<b>Application Ref:</b>	3/2025/0623			 Ribble Valley Borough Council www.ribblevalley.gov.uk
<b>Date Inspected:</b>	N/A	<b>Site Notice:</b>	N/A	
<b>Officer:</b>	LW			
<b>DELEGATED ITEM FILE REPORT:</b>				<b>PERMISSION REQUIRED</b>

<b>Development Description:</b>	Prior notification for demolition of existing conservatory and construction of proposed single storey rear extension 6m long, 4.2m wide, 2.6m high to eaves and 3.5m high to ridge under Part 1 Class A of the GPDO.
<b>Site Address/Location:</b>	Gleneagles, Clitheroe Road, Whalley, BB7 9AQ.

Proposed Ground Floor

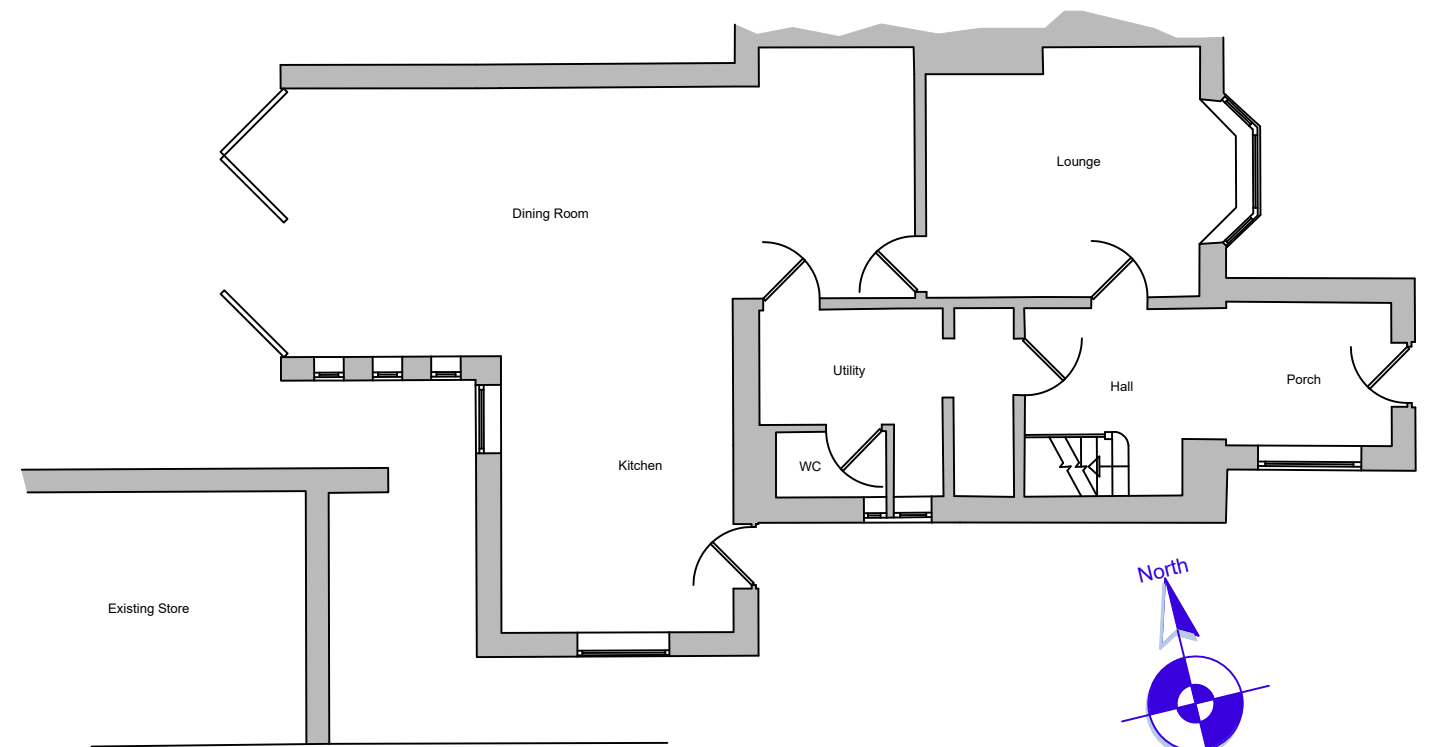
**The proposed development would adjoin the existing two-storey side/rear extension which was granted consent under application reference 3/2003/0072. The total enlargement, being the proposed extension together with the existing two-storey extension, would exceed the limits set out in sub-paragraphs (h), (i) and (j) insofar that the enlargement would have more than a single storey and extend beyond the rear wall of the original dwellinghouse more than 3m, be within 2m of the curtilage boundary and have a maximum eaves height greater than 3m, and extend beyond the side elevation of the original dwellinghouse with more than a single storey, a height in excess of 4m and width greater than half the width of the original dwellinghouse. As such, the proposal fails to comply with criterion (ja) and therefore does not fall to be permitted development in the first instance.**

The proposed extension would project 6m along the common boundary with Amber Lea which benefits from an existing window opening to its rear elevation, adjacent to the boundary with the application property. Whilst the development would replace the existing conservatory featured to the rear of the application property, it would project approximately 2.6m further along the aforementioned shared boundary with a height of 3.5m. The rearward projection of the extension, together with its southerly position in relation to Amber Lea would result in a detrimental impact upon the neighbouring occupants by way of overshadowing and loss of light to the aforementioned window.

Proposed Elevations  
1:100@A3

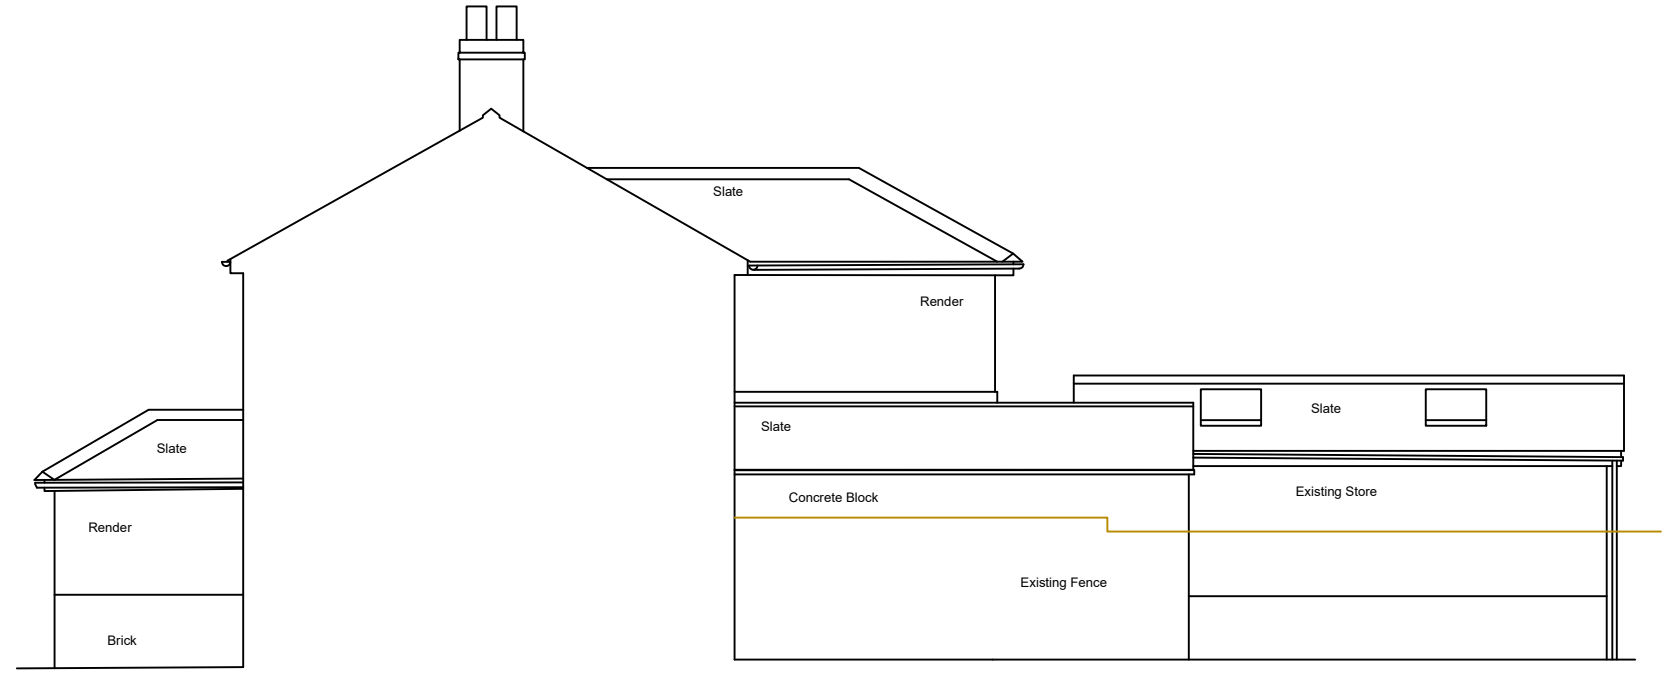
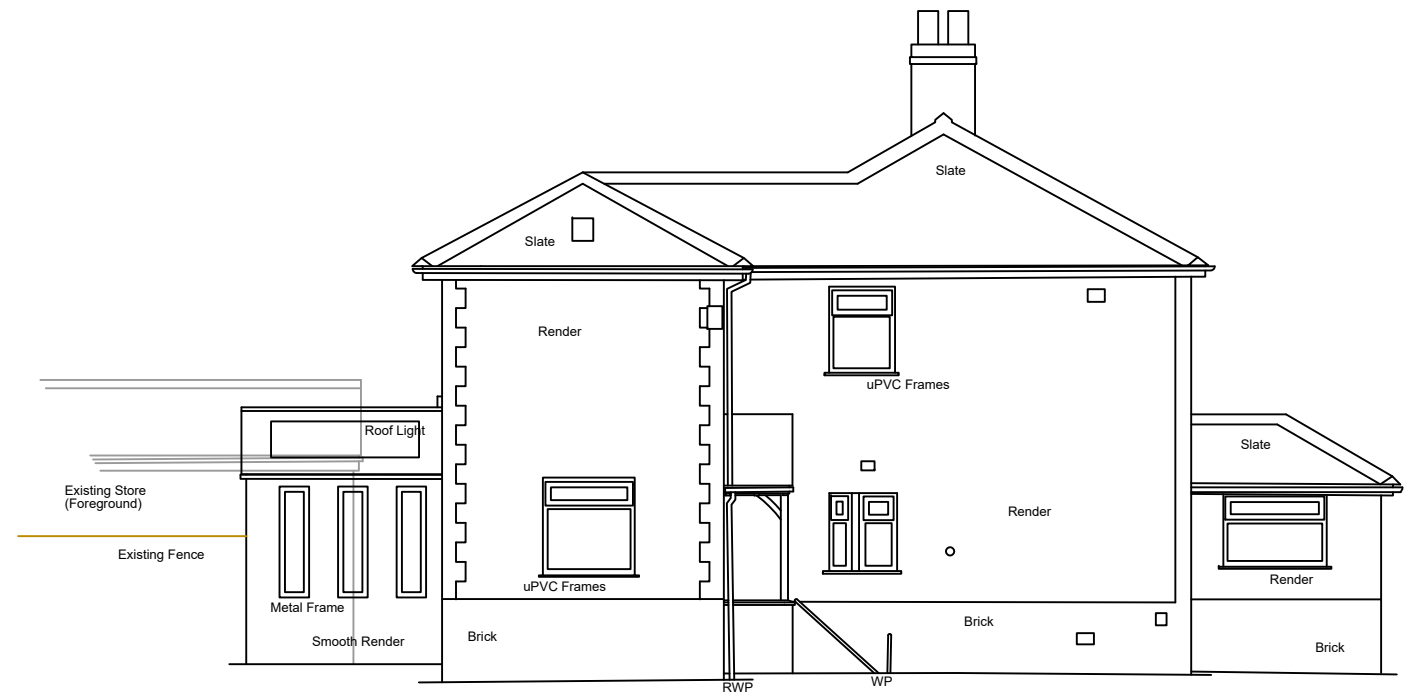
**The proposed extension would be within 2m of the curtilage boundary; however, the eaves height would not exceed 3m.**

**The extension would utilise slate roof tiles and render which would be of a similar appearance to the external facing materials featured to the existing dwellinghouse.**

**The proposed extension would incorporate a large element of glazing to the western facing rear elevation and southern side elevation. Despite this, the proposed openings would not have a direct interface with any neighbouring residential properties so as to result in any new opportunities for direct**
